Rezoning Transportation Analysis
Petition Number: Insert Zoning Petition #2021-285
General Location Identifier: 12105618

Revision Log:	Date	Description
	05-18-2022	First Review (WB)
	06-16-2022	Second Review (WB)

JOB NO.: 2021-119  
 DRAWN BY: MDV  
 DATE: 12.22.21  
 SCALE: 1"=10'  
**SCHEMATIC SKETCH PLAN**  
**RZ.1**

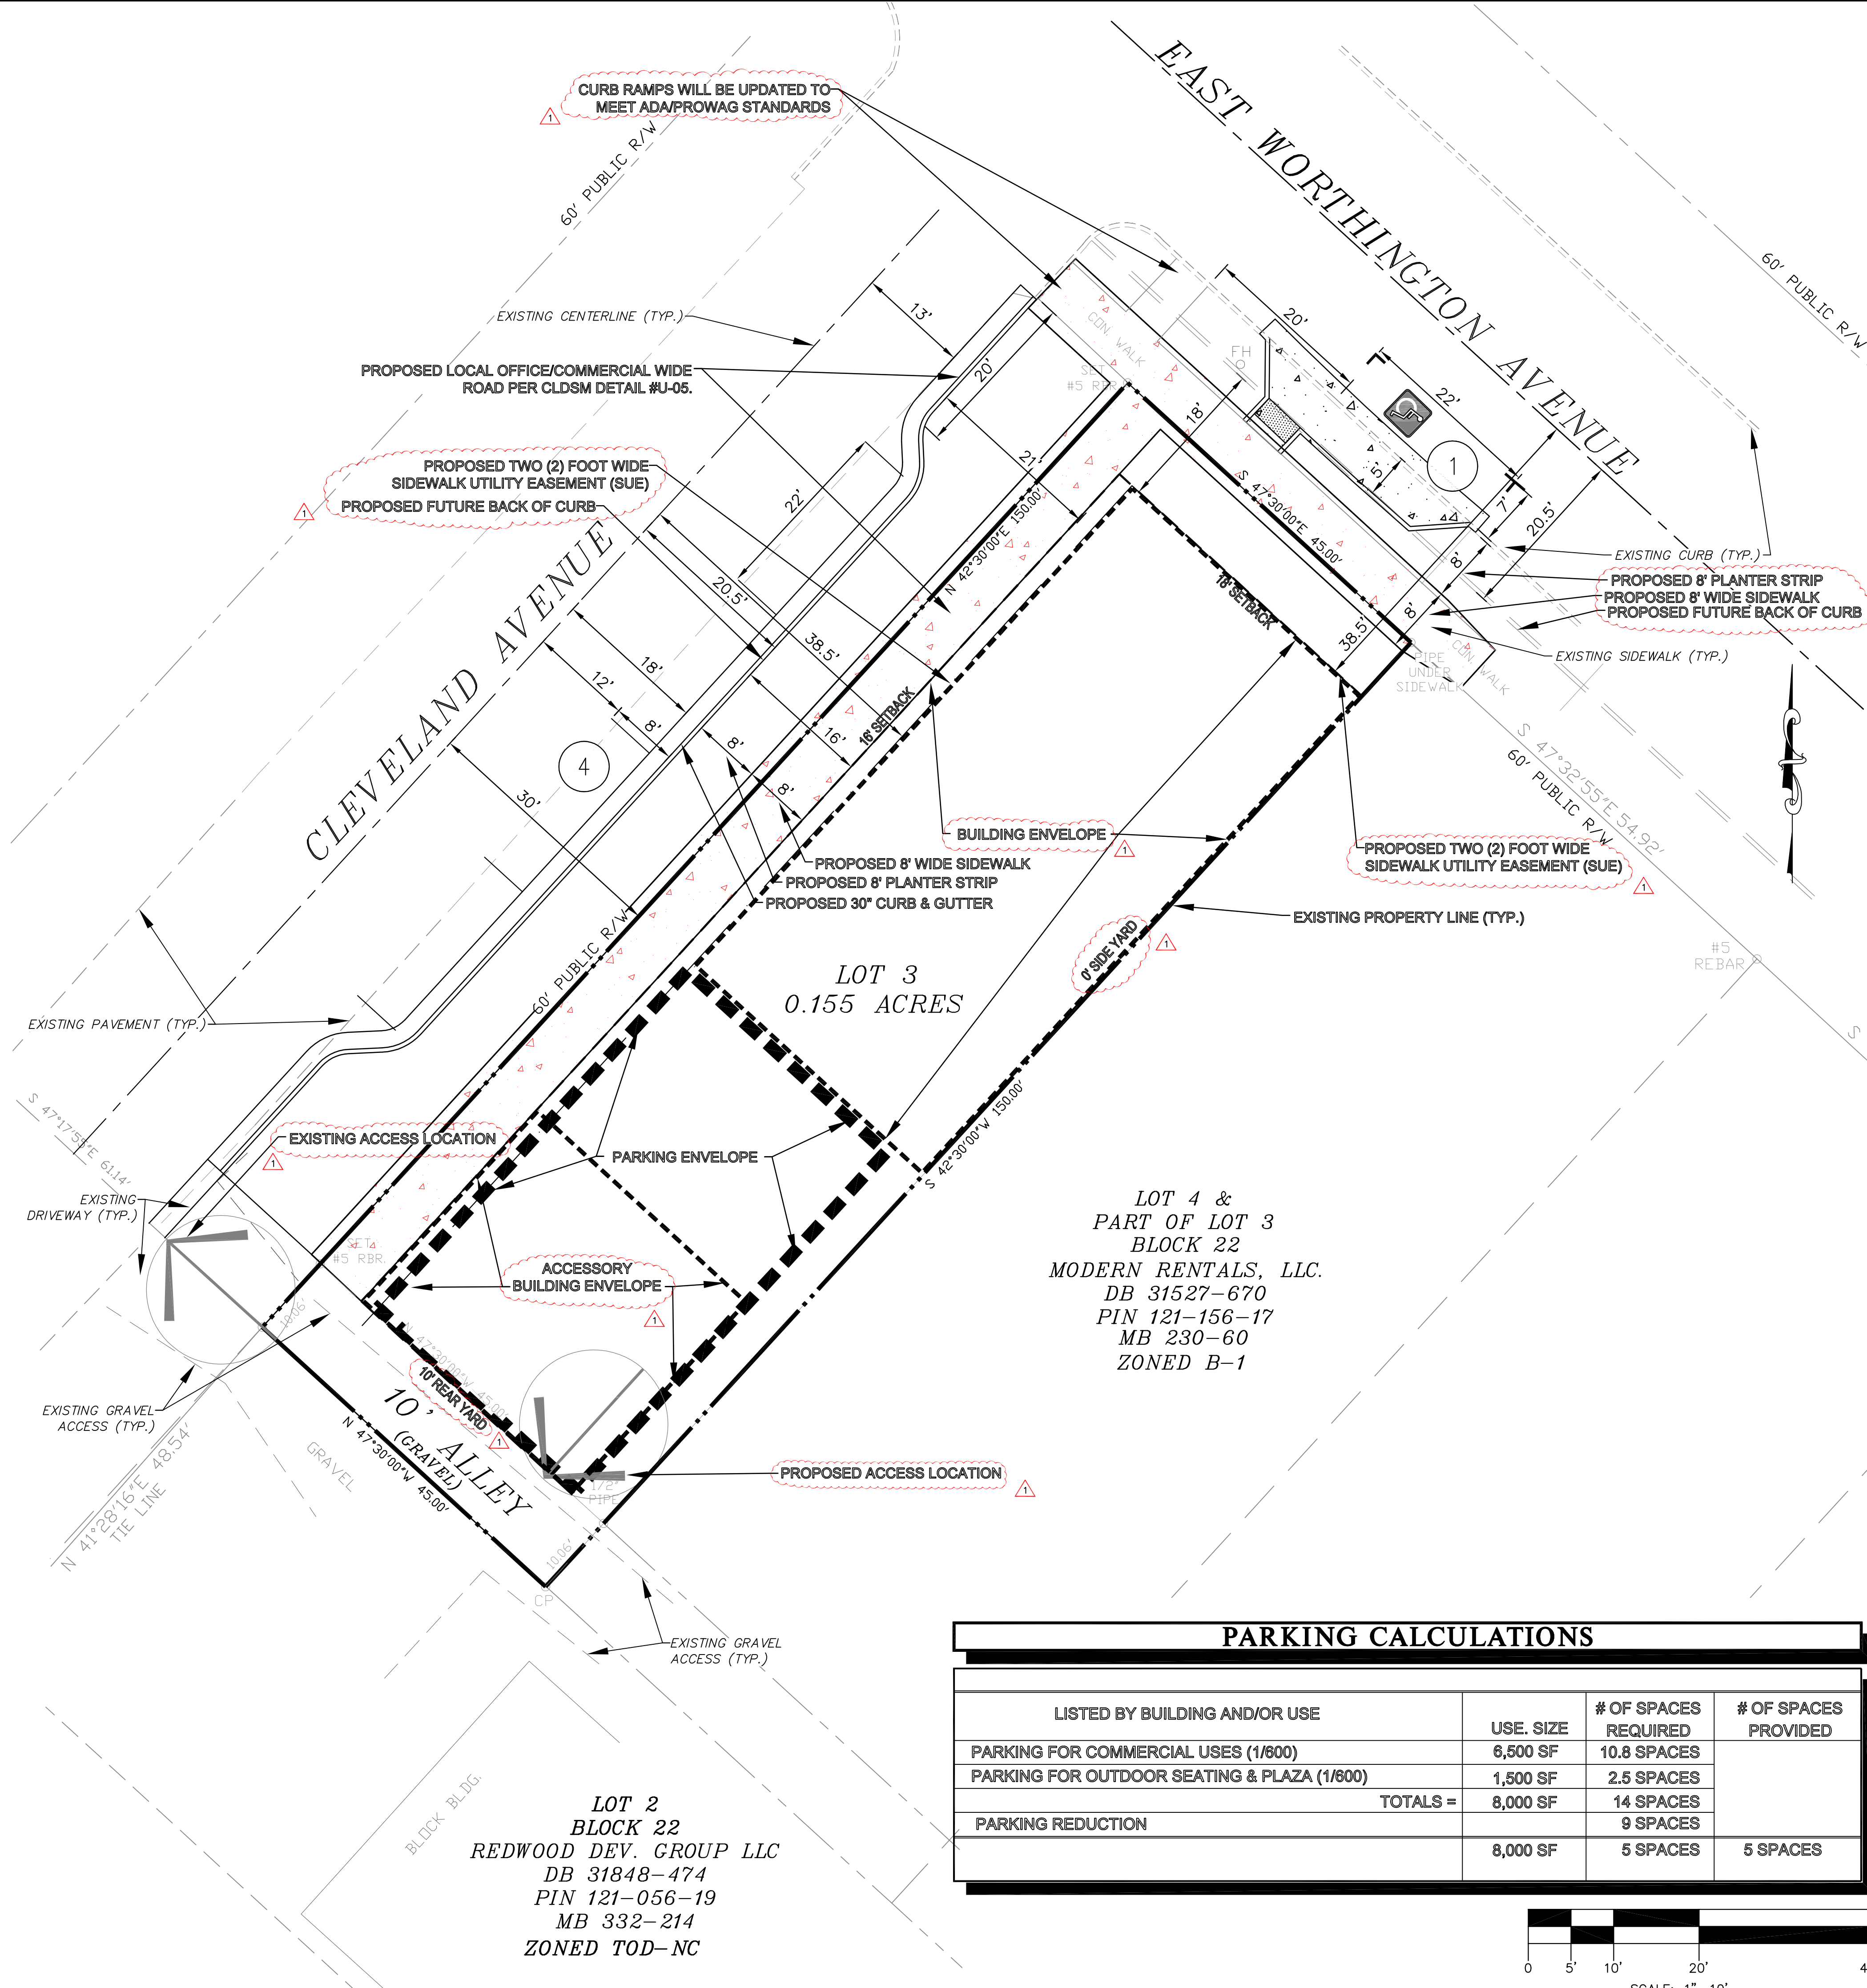
1. **Curbline:** The proposed zoning district has a setback measured from back of the existing or proposed future curbline.
 - a. **Cleveland Avenue:** ~~The future curb and gutter shall be located 20.5 ft from the centerline. This offset represents a Local Commercial Wide Typical section with on-street parking along the site's frontage.~~
 - b. **East Worthington Avenue:** ~~The future curb and gutter shall be located at 20.5 ft from the centerline. This offset represents a Local Commercial Wide Typical section with on-street parking along the site's frontage. No relocation of the Curb & Gutter is required on East Worthington due to existing mature trees; however, plans must label and dimension the future location.~~

~~Label and dimension the curb and gutter from the centerline for each road on the site plan.~~
2. **Traffic Study:**
~~A Traffic Impact Study (TIS) is not necessary for the complete review of this petition due to the site generating less than 2,500 daily trips. If during the permitting process the site generates more than 2,500 daily trips, then a traffic study will be required.~~

3. ~~Revise site plan and conditional notes to label and dimension the East Worthington Avenue right-of-way from the road centerline. The site plan shall label and dimension the right-of-way from the road centerline.~~

4. ~~Revise site plan and conditional notes to label a 2-ft sidewalk utility easement (SUE) 2 ft behind the future back of sidewalk for Cleveland Avenue and East Worthington Avenue (30.5 ft from the centerline).~~

5. ~~Revise site plan and conditional notes to commit to installing ADA compliant curb ramps at the Cleveland Avenue and East Worthington Avenue intersection.~~

- ~~6. Revise site plan and conditional notes to commit to construct an 8-foot planting strip, and 8-foot sidewalk on East Worthington Avenue per Chapter 19 and CLDSM U-05A. The site plan shall label and dimension both items from the back of curb and gutter and road centerline.~~
- ~~7. Revise site plan to identify the proposed access to the proposed parking identified on the site plan.~~
